12 November 2019

Department of Planning, Industry & Environment
GPO Box 39
SYDNEY NSW 2001

**RE: Submission – Snowy 2.0 – Exploratory Works – MOD 2 – Tunnelling Methodology
(SSI-9208-Mod-2)**

Snowy 2.0  
Exploratory Works  
Modification 2  
Figure 3.7

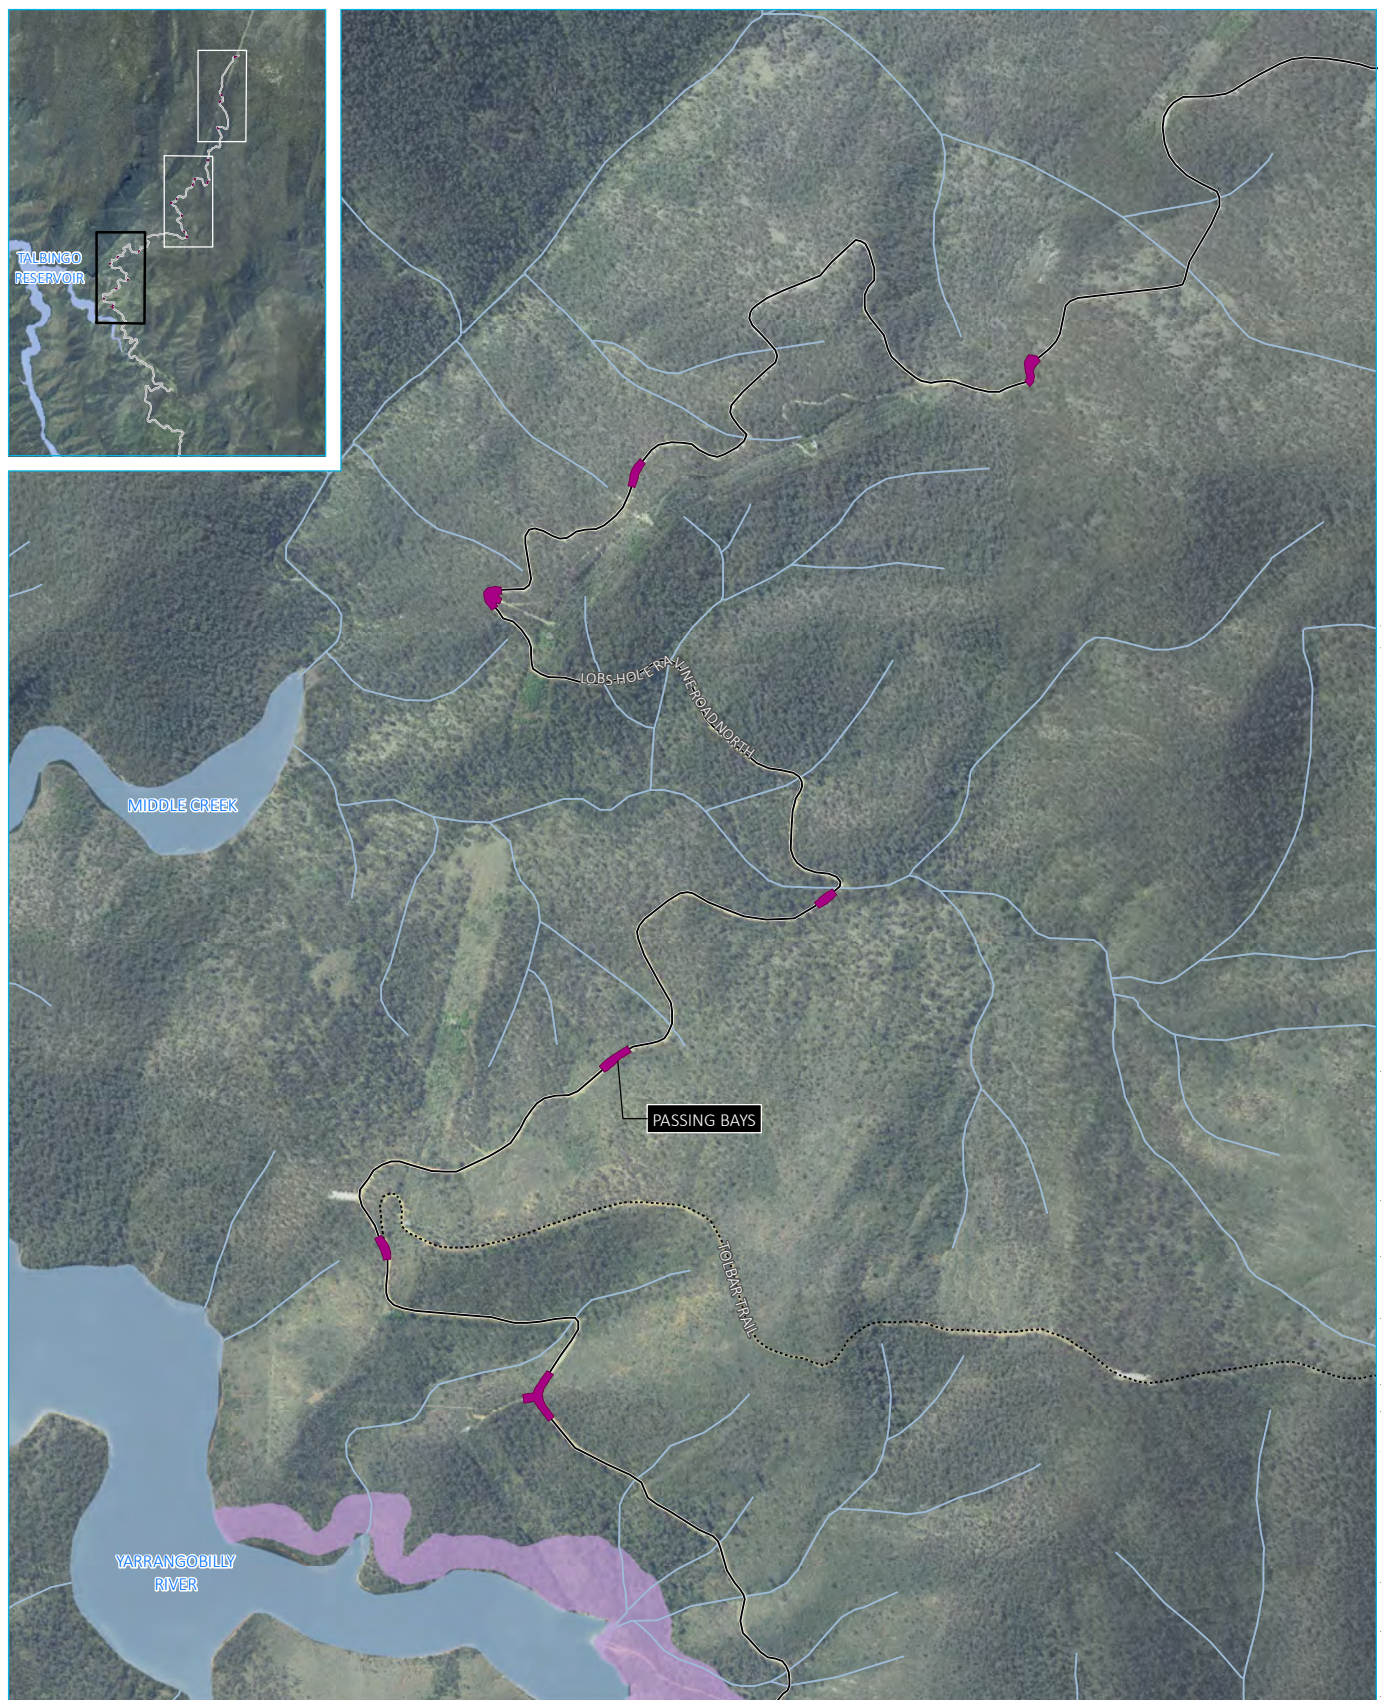
SMRC supports the proposal for alterations to be made to the roundabouts in the Cooma CBD and recognises the importance of necessary improvements along major freight routes.

SMRC notes the requirement for the proposed upgrades to suit the OSOM movements for the project and encourages that discussions be held between SMRC and SHL to finalise the upgrade design. It is considered that RMS should also be involved in this process.
